**From:** Rachel . <blparishclerk@outlook.com>  
**Sent:** 19 July 2022 18:06  
**To:** Planning  
**Subject:** 3/2022/0580

The parish council would like to strongly object to this application on the following grounds.

drawing title	Existing Site Plan
dwg purpose	
scale 1 : 200 @ sheet size A1	rev date
job number	EX-SP-001 drawing number revision

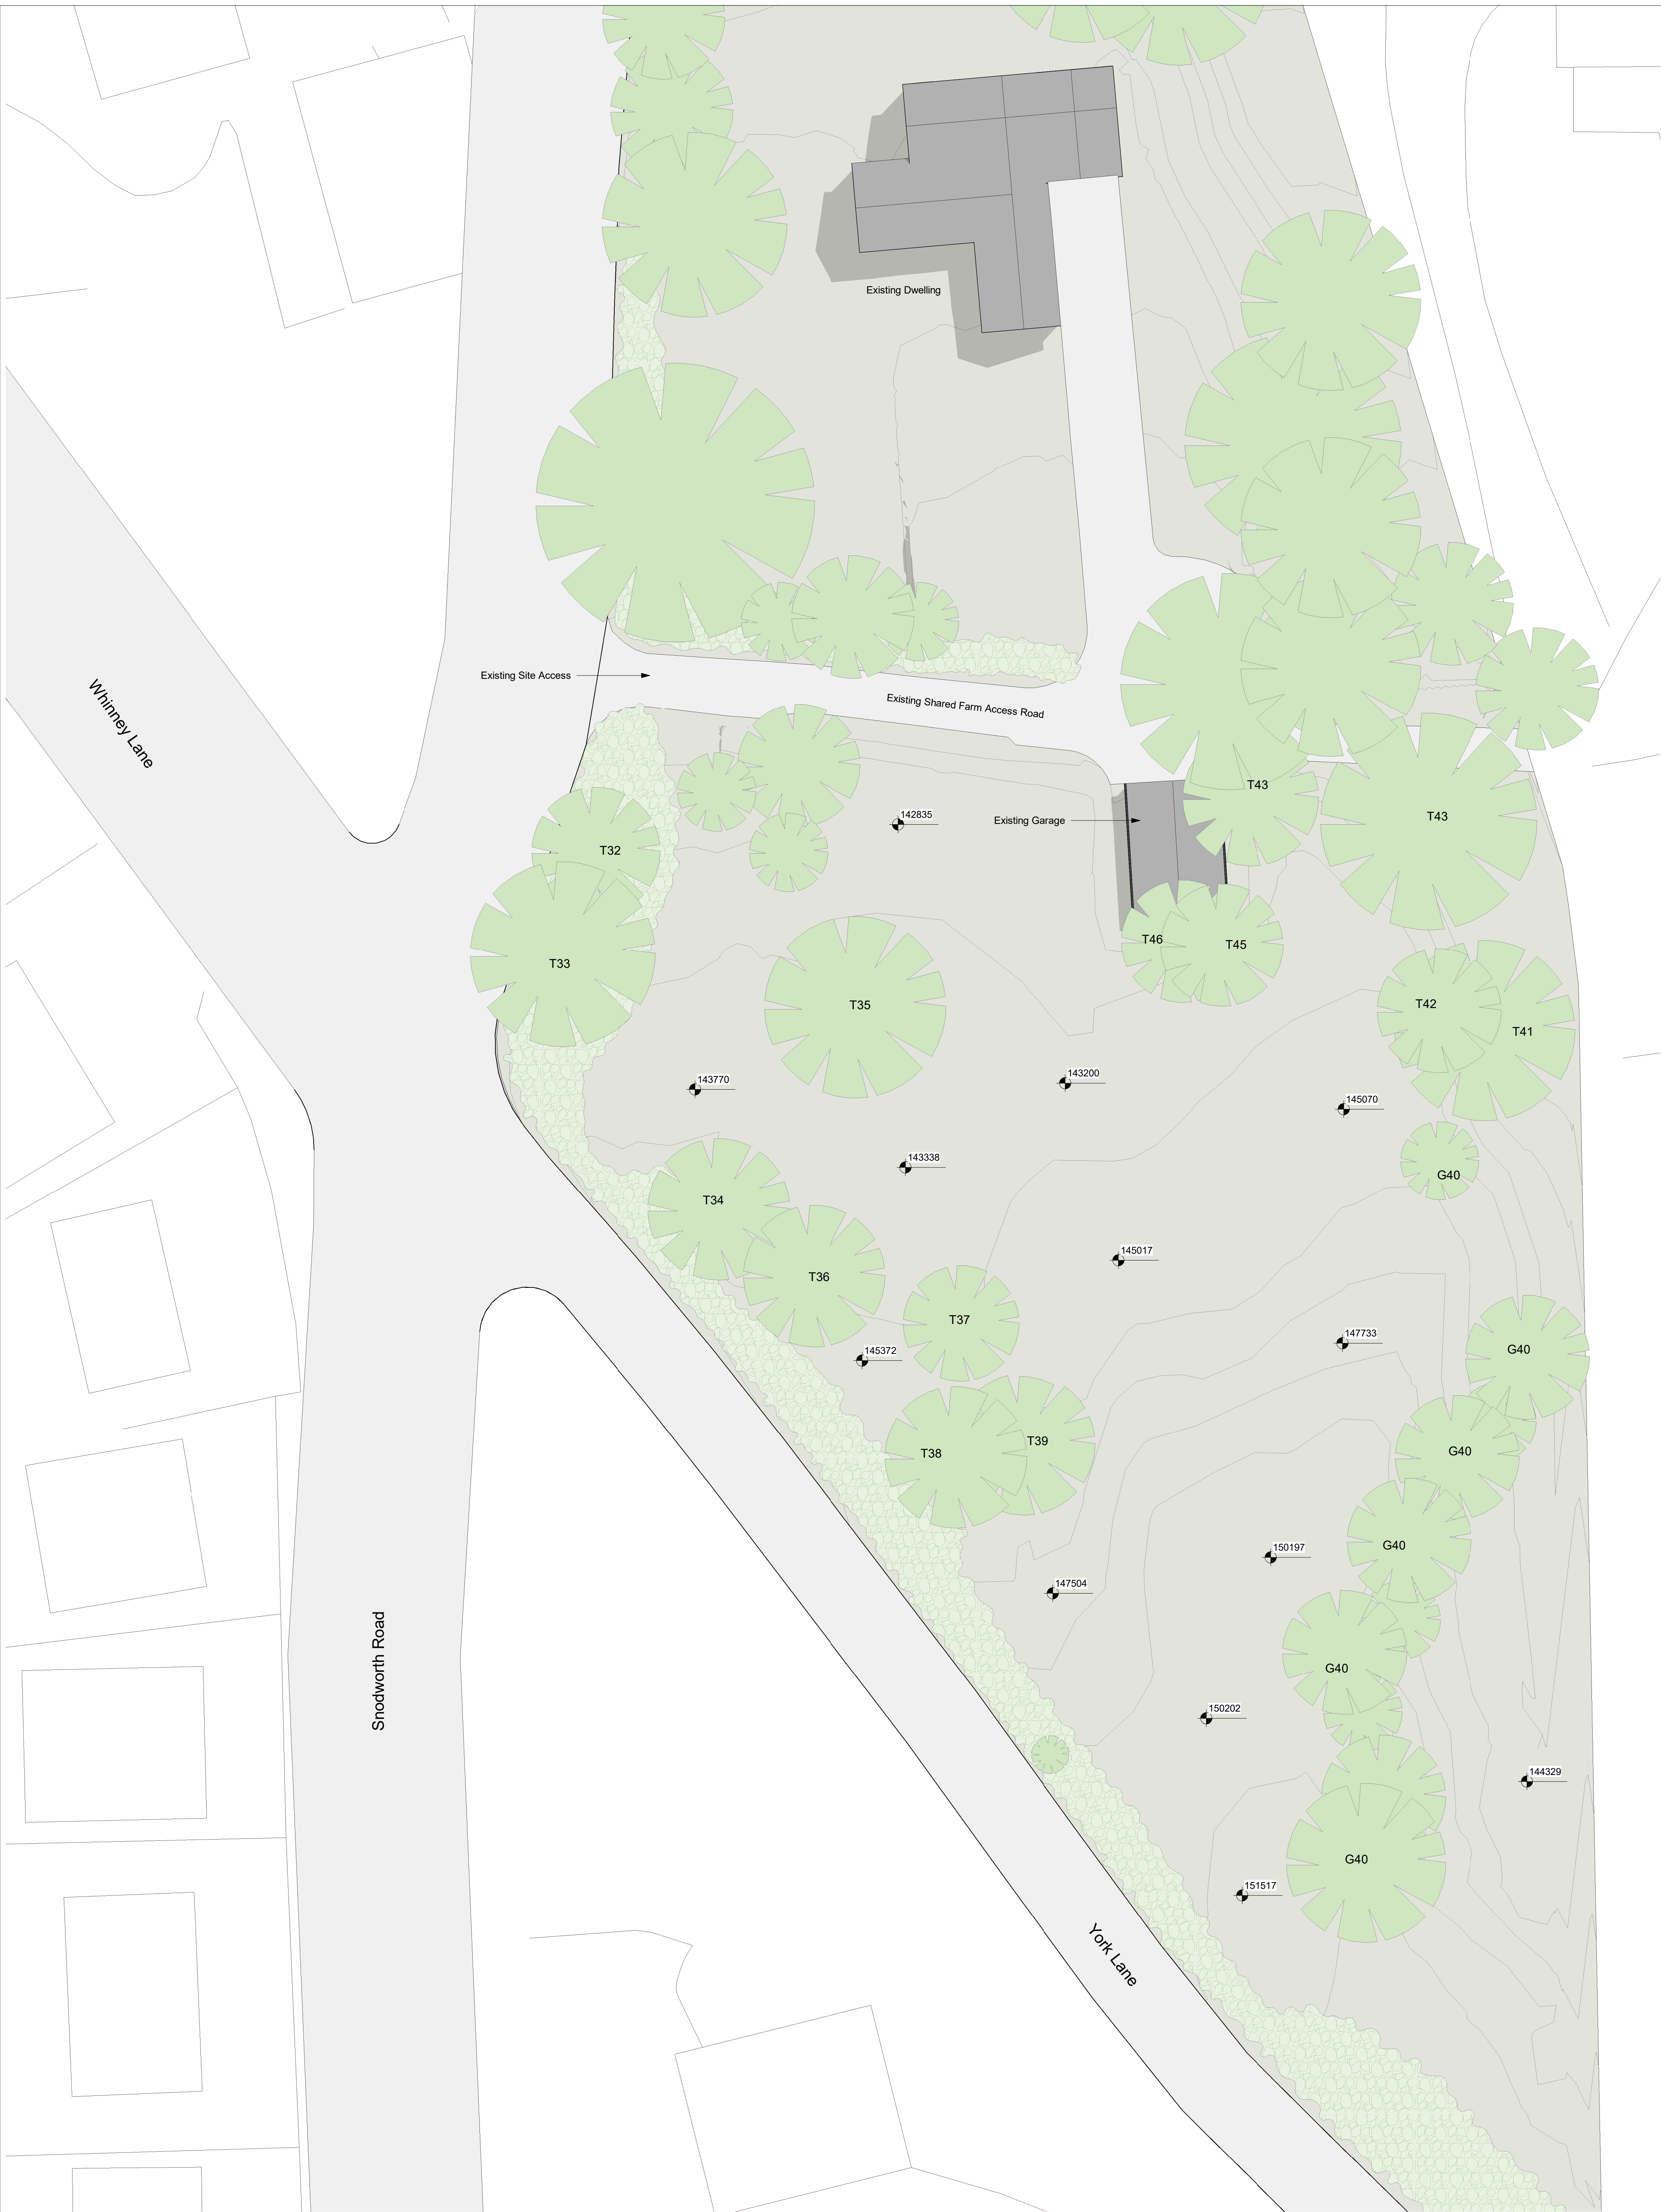
2. York Lane is very narrow at the access point to the proposed development with a bend to the south and a very dangerous and blind junction a few yards to the north. The entrance to the proposed site does not benefit from a footpath on that side of the road and hedges screen vision to the north and south. The splay shown on the applicants drawings is grossly insufficient.

6. The lower access to the proposed site is close to the junction of Whinney Lane and York Lane and we know too much traffic travels too fast on Whinney Lane already. The further higher access will be dangerous onto a narrower part of York Lane, which is still a minor rat-run and the vision splays are way too short for the actual speeds there; if you did make the splays wide enough, you would need to demolish a stretch of decent stone wall that enhances the street-scene at that point.
